Lead Member of the Examining Authority
Five Estuaries Windfarm DCO
National Infrastructure Planning
Temple Quay House
2 The Square Bristol
BS1 6PN

Our Ref D0048269
PINS Ref: EN010115
Date: 11th February 2025

Planning Act 2008**Application by Five Estuaries Offshore Wind Farm Limited for an order granting development consent for the Five Estuaries Offshore Wind Farm project.**

OVERALL SITE LAYOUT -GIS

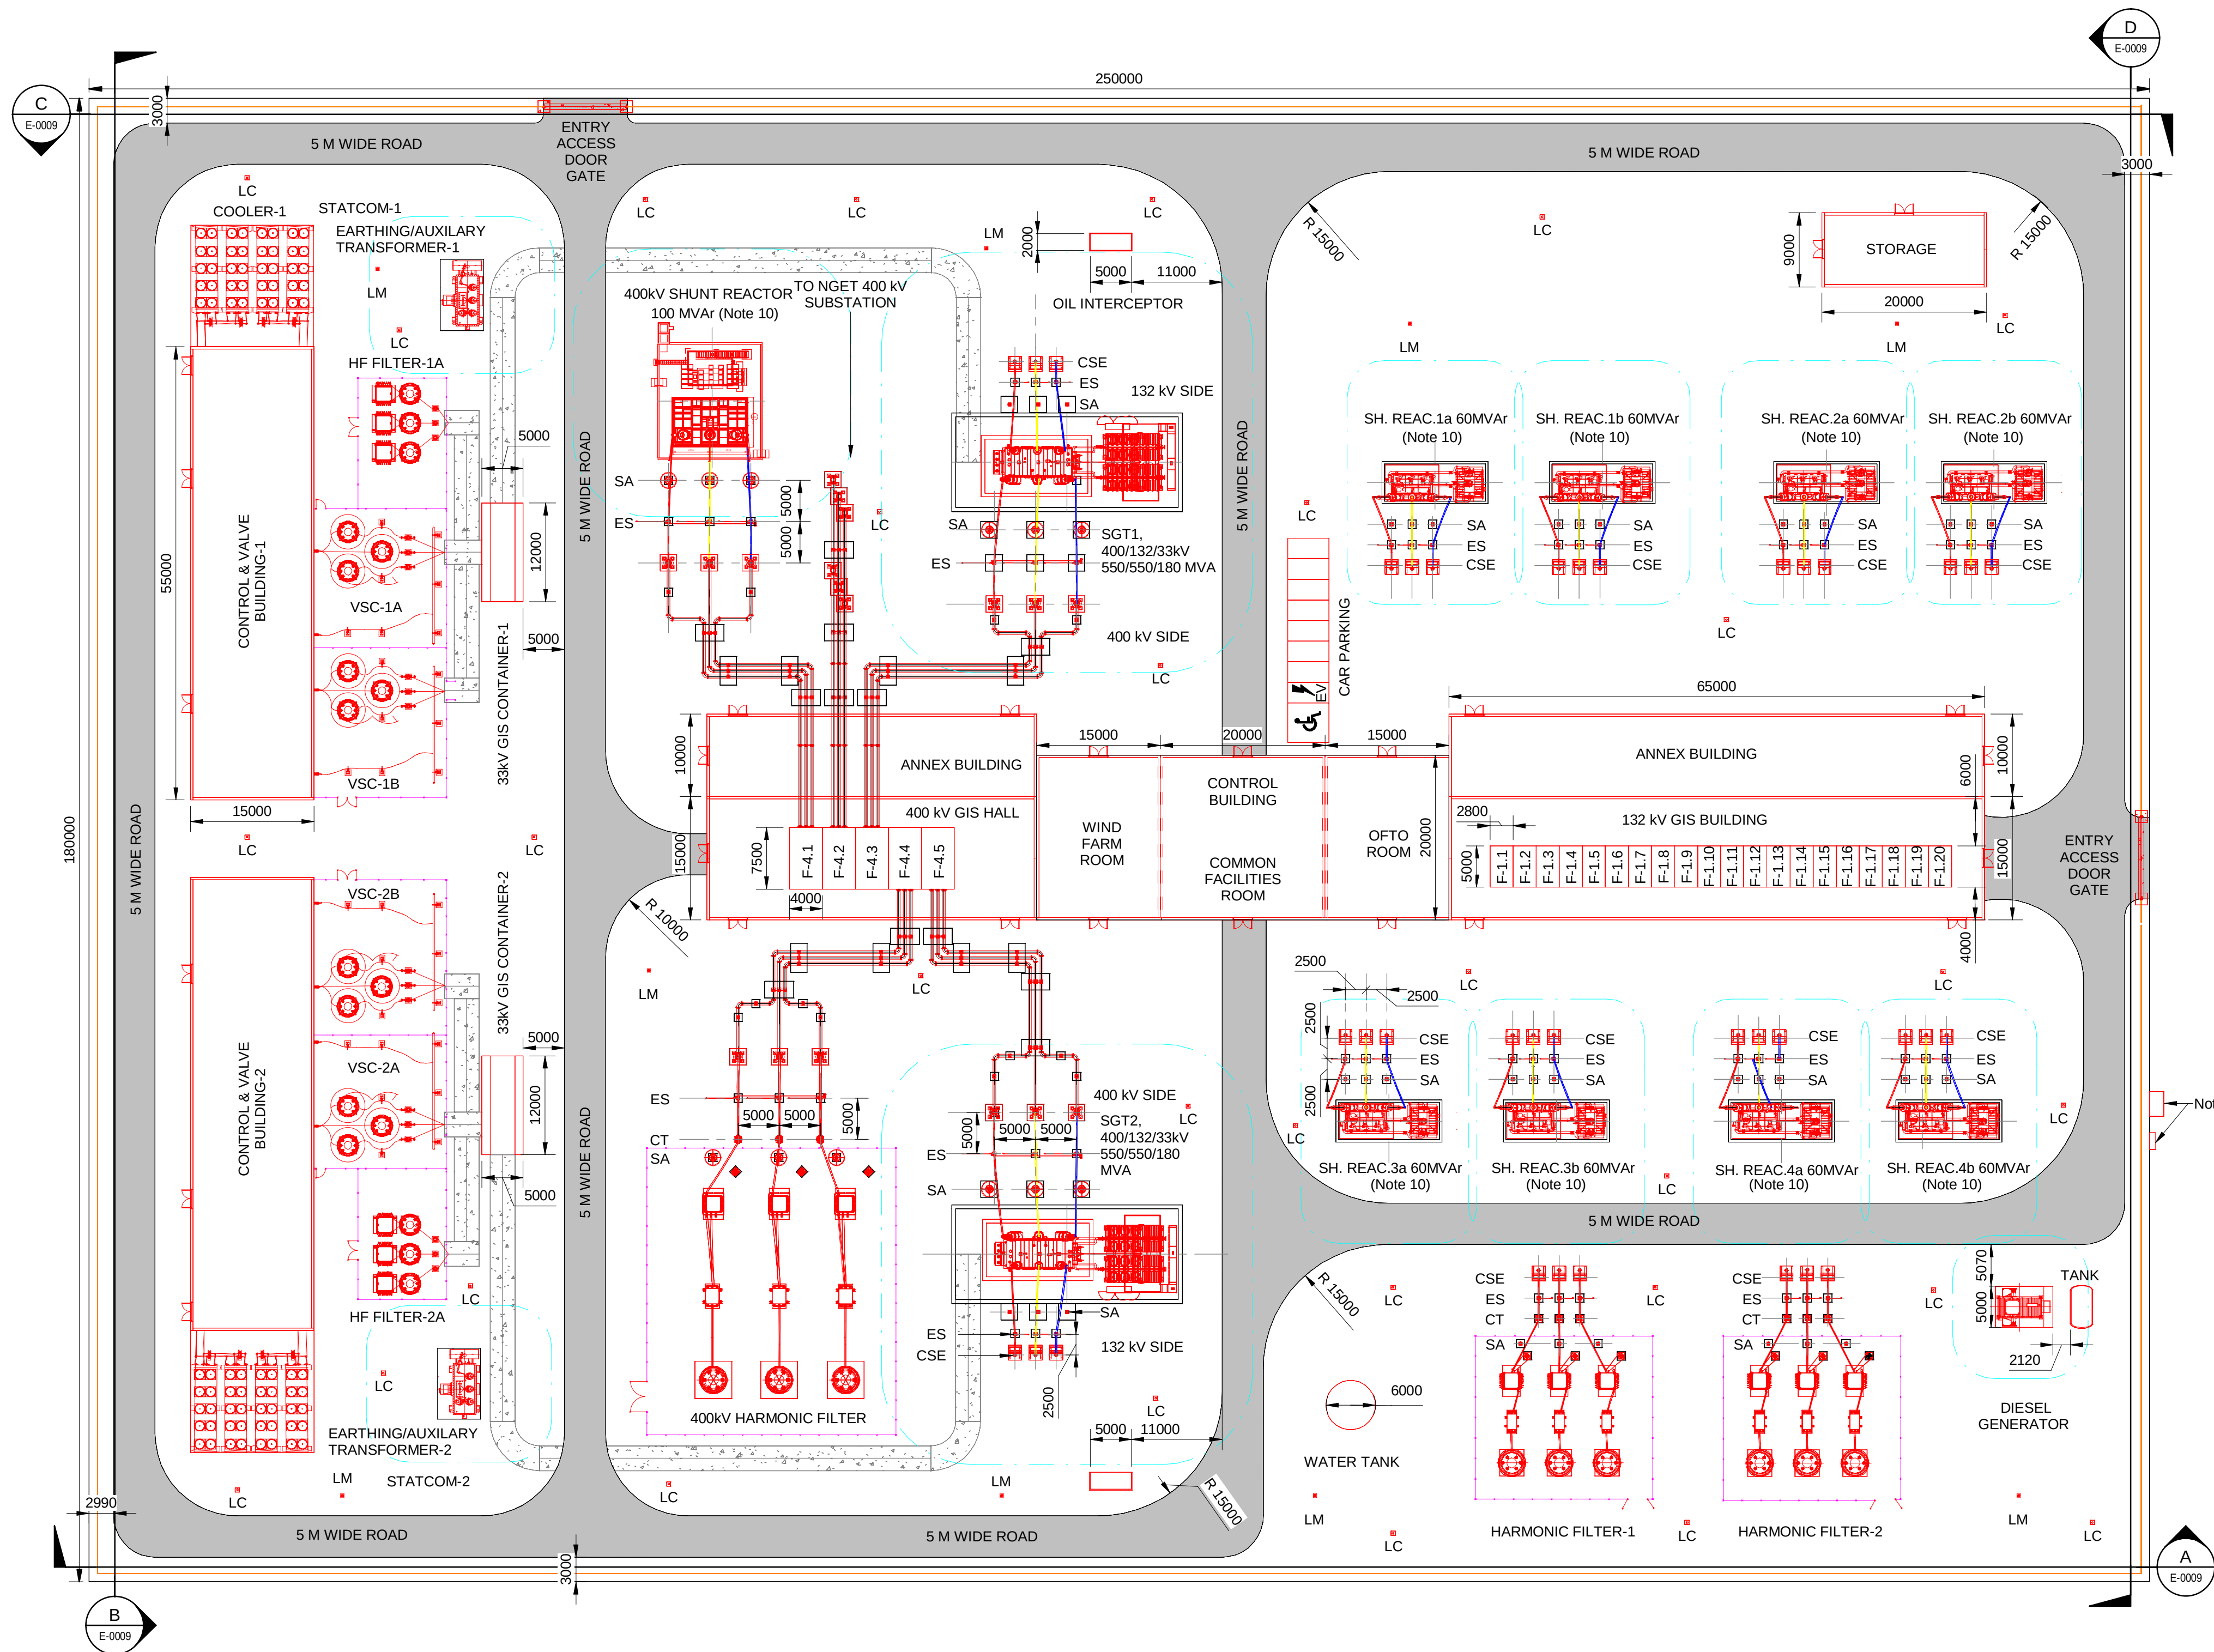
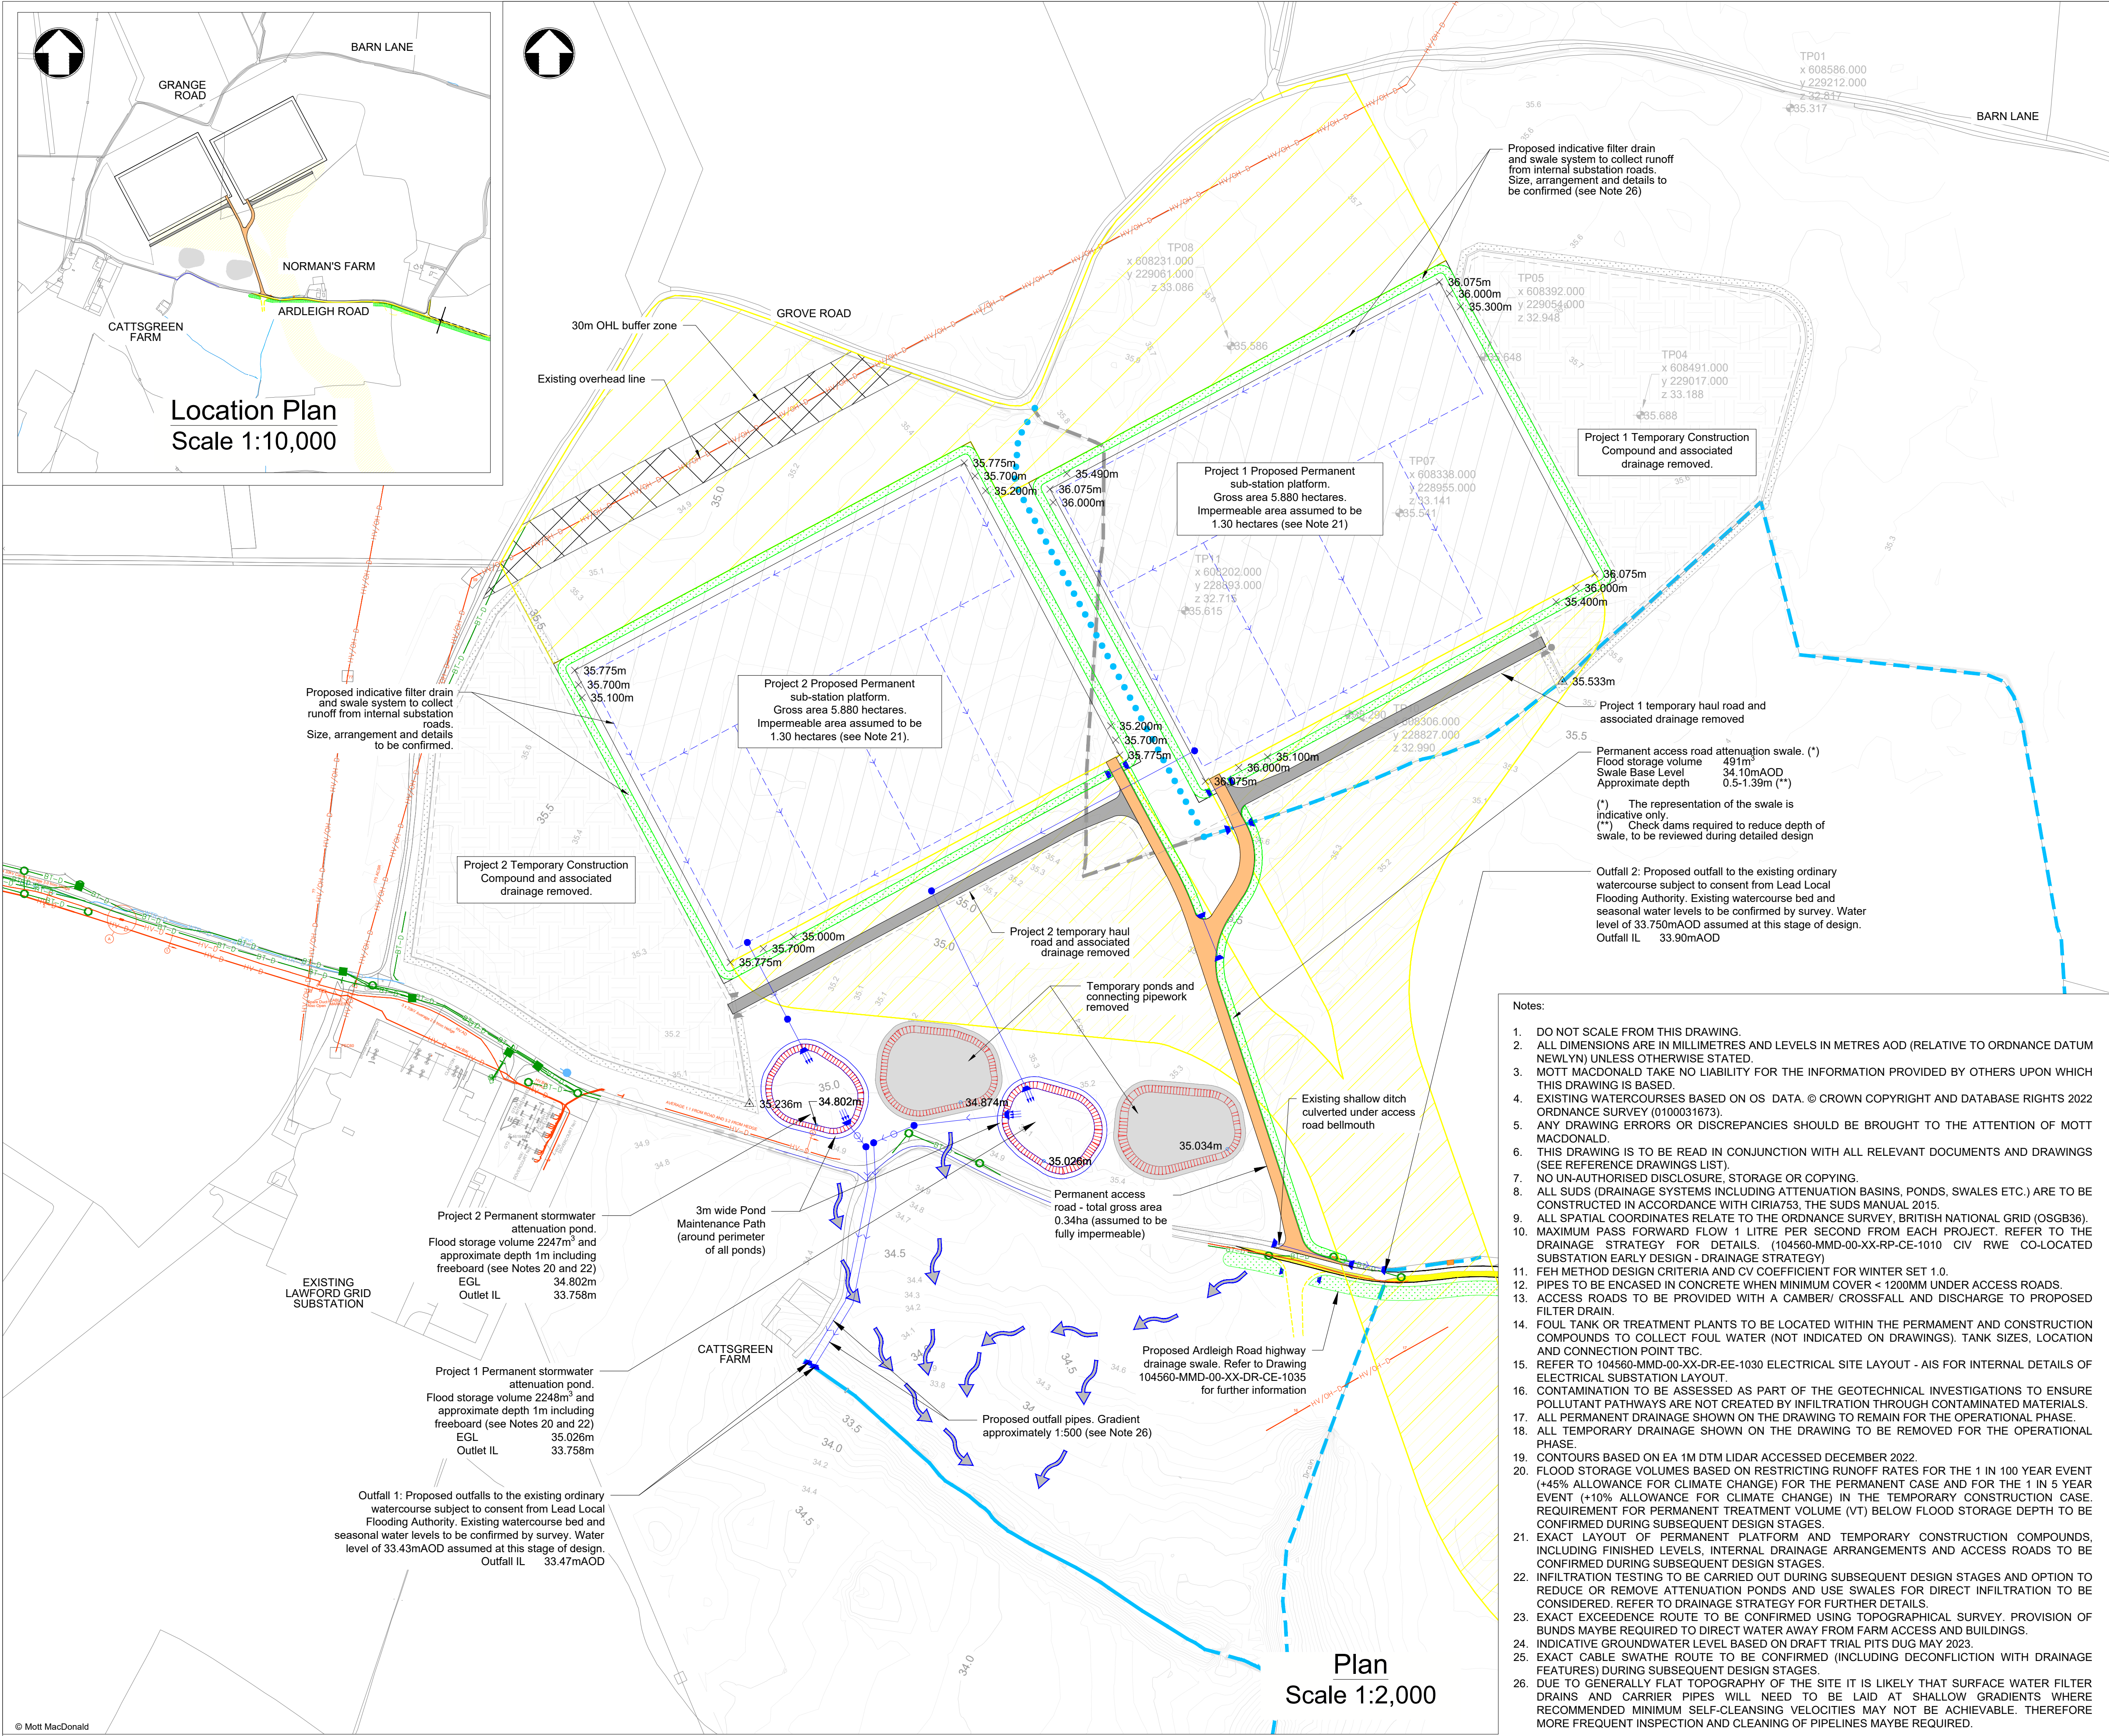
Design Principles – the Councils have previously requested that cross-sections through the substation and proposed planting belts are provided to demonstrate that they will provide effective screening from Years 10-15 as claimed. The Councils remain unconvinced that all negative visual impacts can be mitigated and cross-sections would be an effective way to provide further evidence.

The Councils do not agree that the proposed orchard planting to the north of the facility will provide screening to the substation although accept it will enhance biodiversity and visual amenity.

In relation to the proposed planting belts, we would wish to see the often discussed proposed 20m width of these enshrined as a parameter in the oLEMP as previously discussed, in order to ensure this key part of the mitigation vision is carried out at the post consent stage.

In relation to *landscaping around the substation* the Councils would wish to see some parameters included in the oLEMP for the scale of the planting plans to come forward at consent stage in order to ensure the plans are fit for purpose. We suggest 1:1000-1:2500 might be appropriate for this facility but are happy to discuss this further with the Applicant.
